Your Ref: OWPC18669
Our Ref: P/49/18/HH 30-04-2018
Please ask for:
Mr S Davis

2 storey infill extension to front elevation & 1st
floor infill extension to rear elevation.

39 Conway Drive Pagham

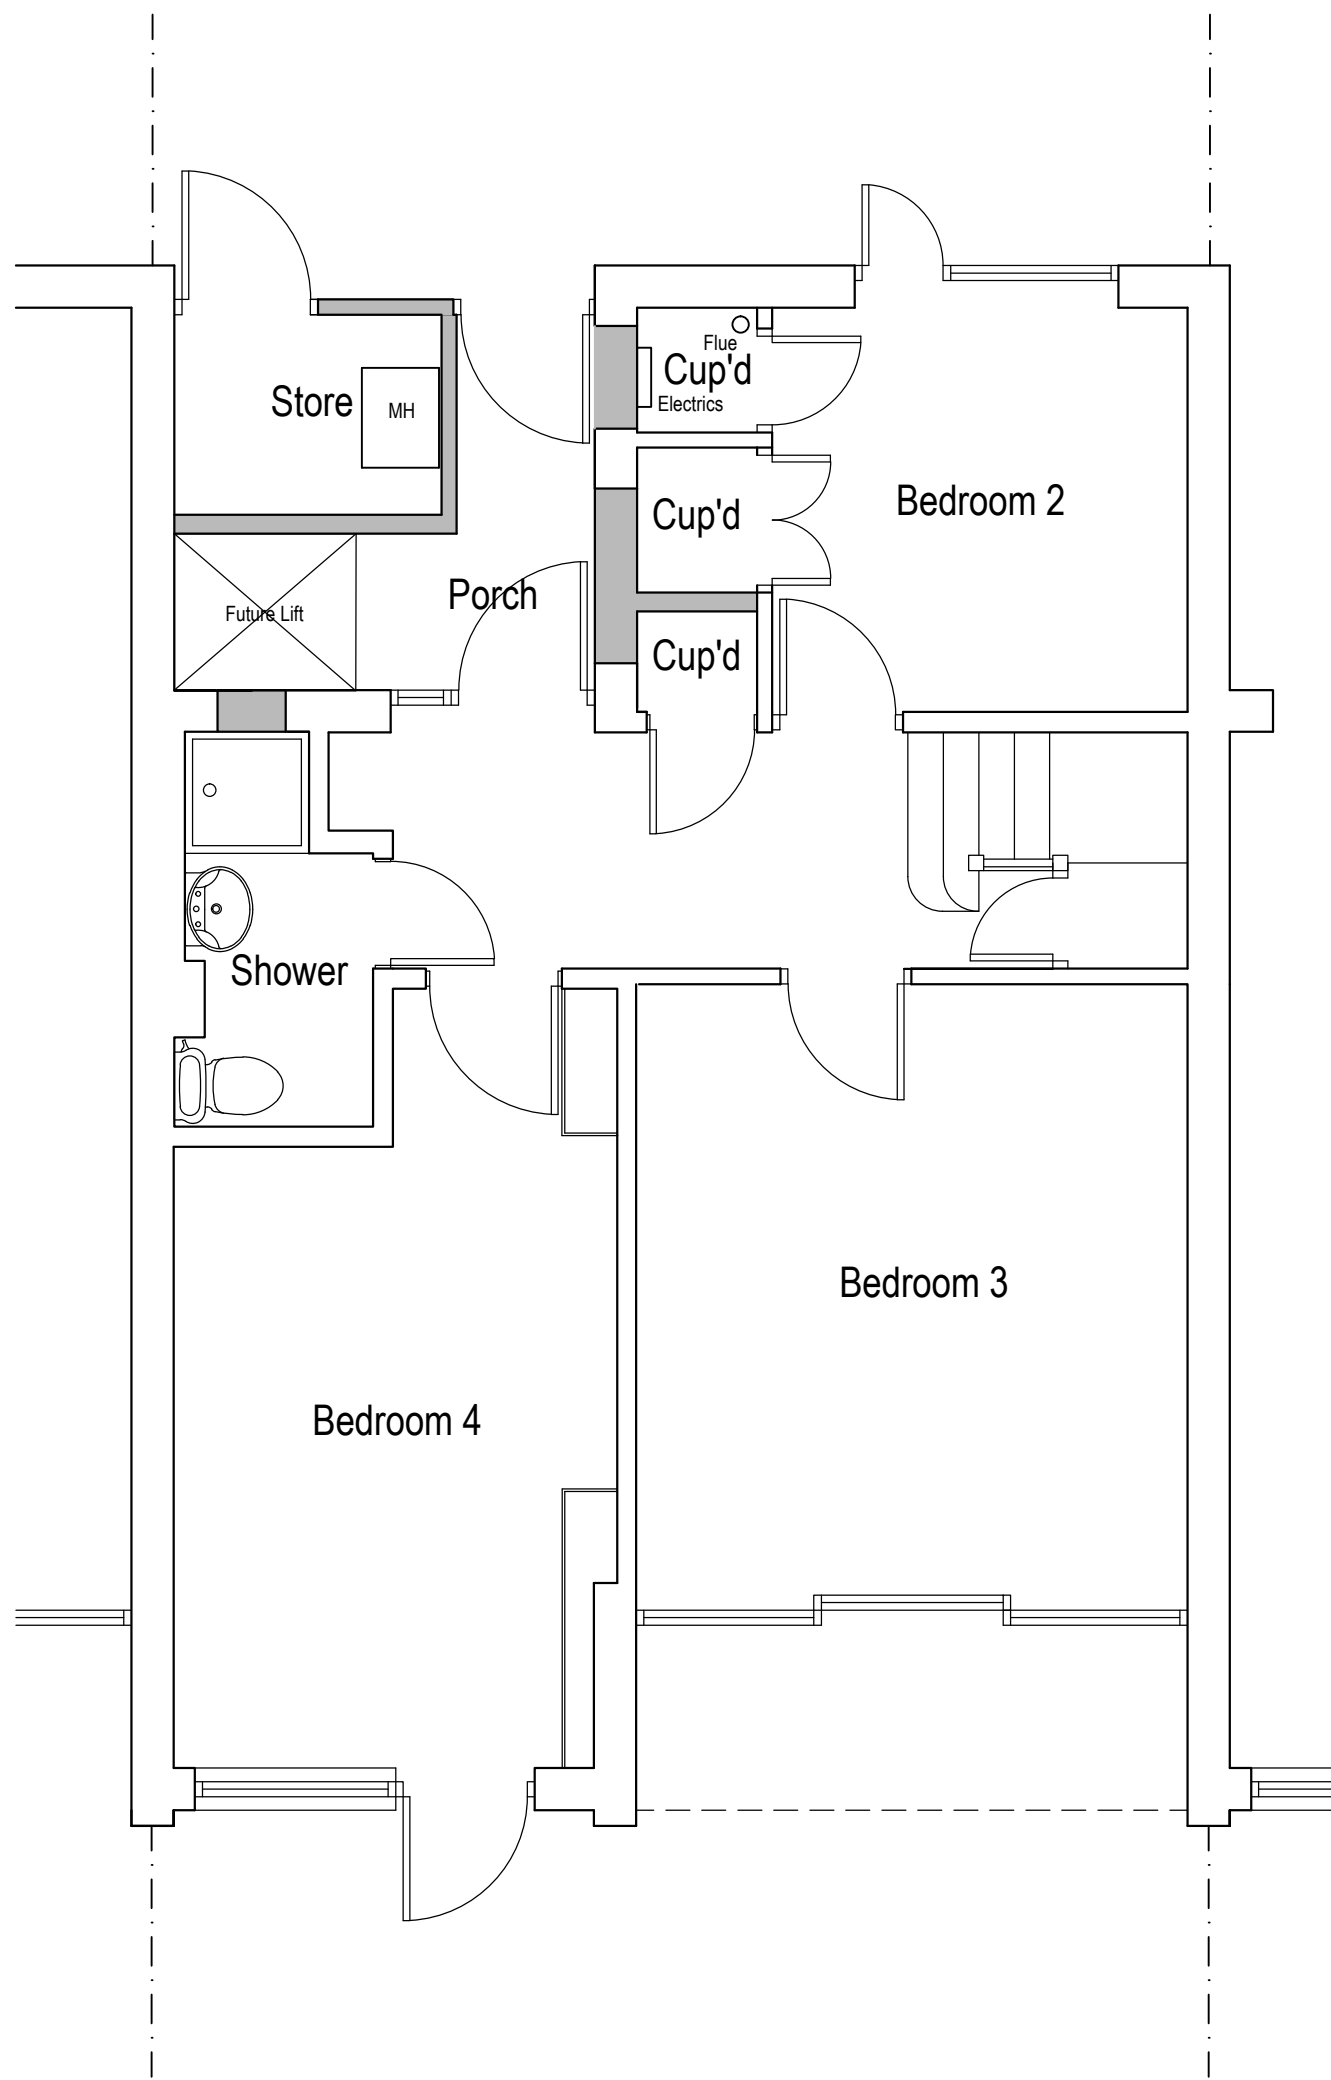
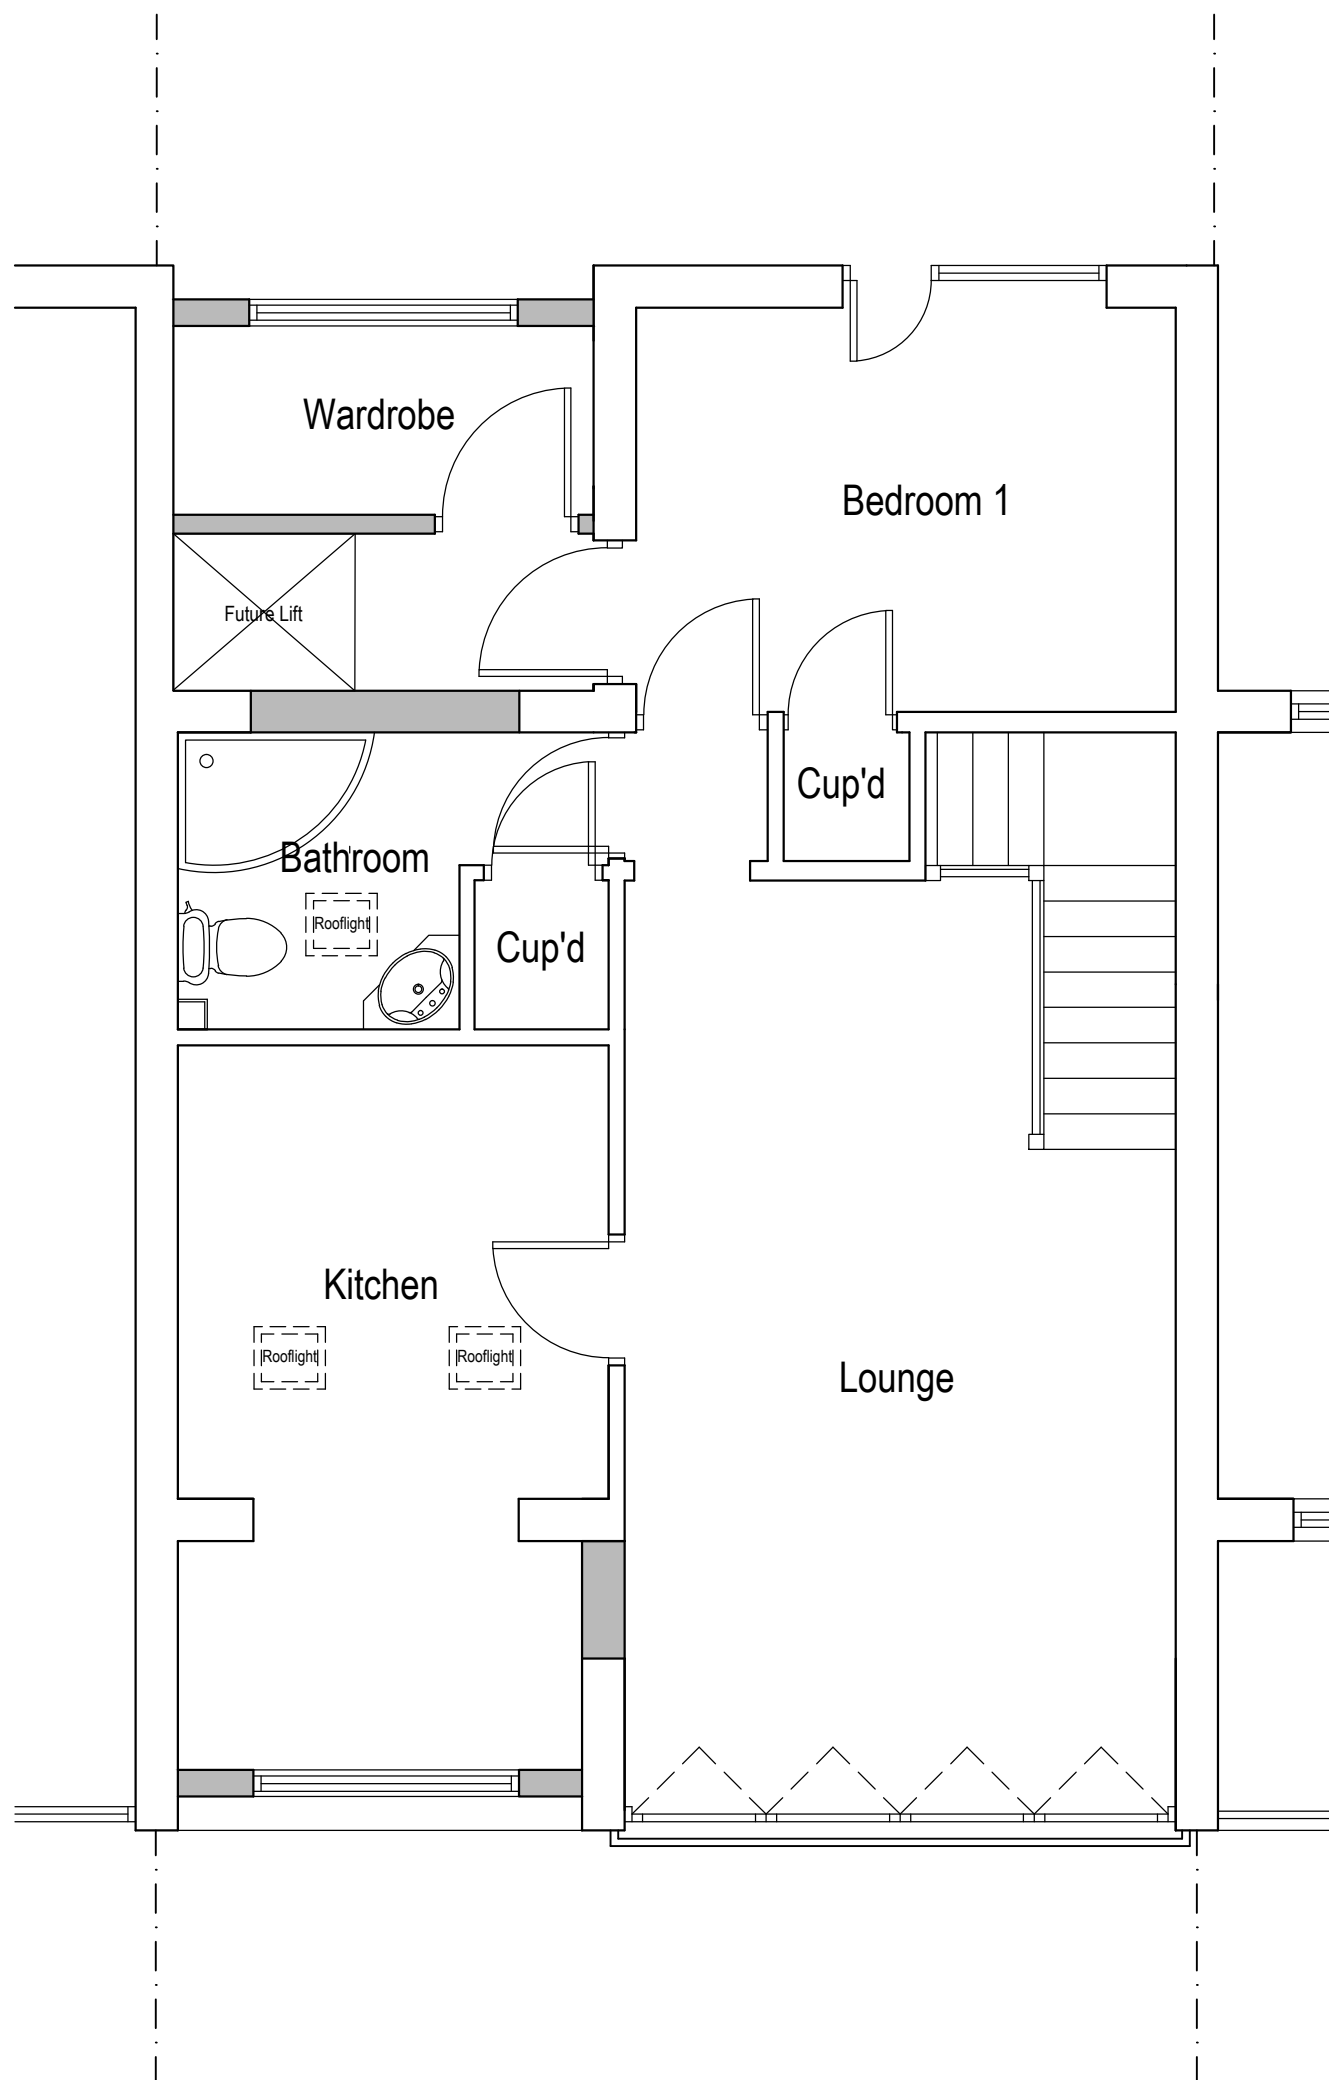
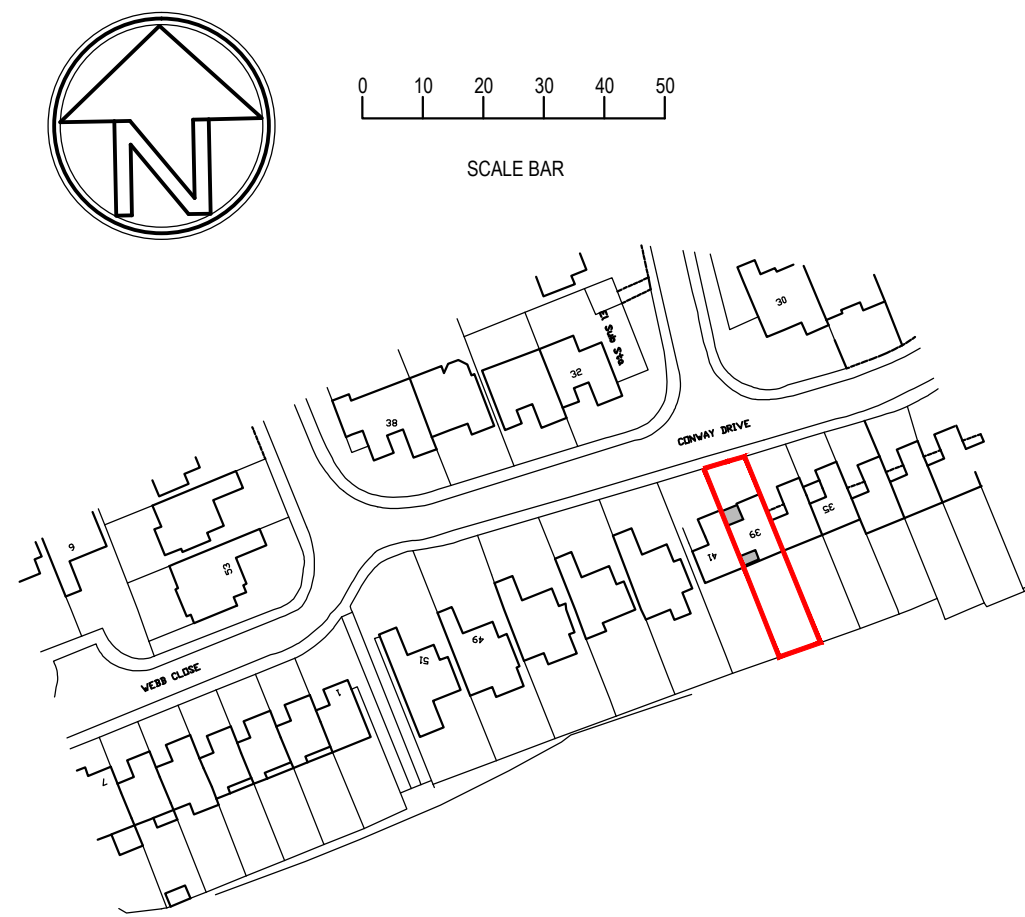
We wish to object to this proposal in the strongest possible terms. This development would ruin the look of this group of four houses. They have been styled to look like four separate houses from the road, with the front aspect heavily recessed in, giving the appearance of link detached houses - .this plan would not only make the front of No39 look like part of ours (No41) and finish level with it, it would also look seriously out of place amongst the other three. If we had wanted to live in a terraced house we would have bought one. Granting this permission would set a precedent and the four houses could end up looking like one flat fronted block- - rather than the, far more aesthetically pleasing four separate dwellings they look like now. The next objection would be the increased sound level due to the increased living space both at the front and rear of the property attached directly to ours. At the moment there is no physical contact between the properties in the balcony area and the front sections and there is no permanent dwelling space in those two areas This would obviously allow for more noise to be transmitted from one house to the next. These four houses have notoriously poor sound proofing and normal level conversation can be heard in adjacent properties some of which is down to the garages being removed in these houses previously.

- - To have more of next doors house in physical contact with ours can only serve to make the situation worse. And of course to potentially have a mechanical lift fitted on what is at present the outside wall of our study and our 8 year old son's bedroom would be completely unacceptable. It is our understanding that No 39s proposed development which would attach to two walls that are our property would require "party wall agreements" to be signed by us and that any failure to obtain them could result in a claim of criminal damage against the neighbour/builder should they touch or indeed damage our wall without permission. This is something that we have no intention of signing, for the above reasons. Our new neighbour who is applying for this planning permission may own the house but hasn't actually moved in yet and experienced the poor sound proofing these houses suffer with, although it has been mentioned to him previously by us.
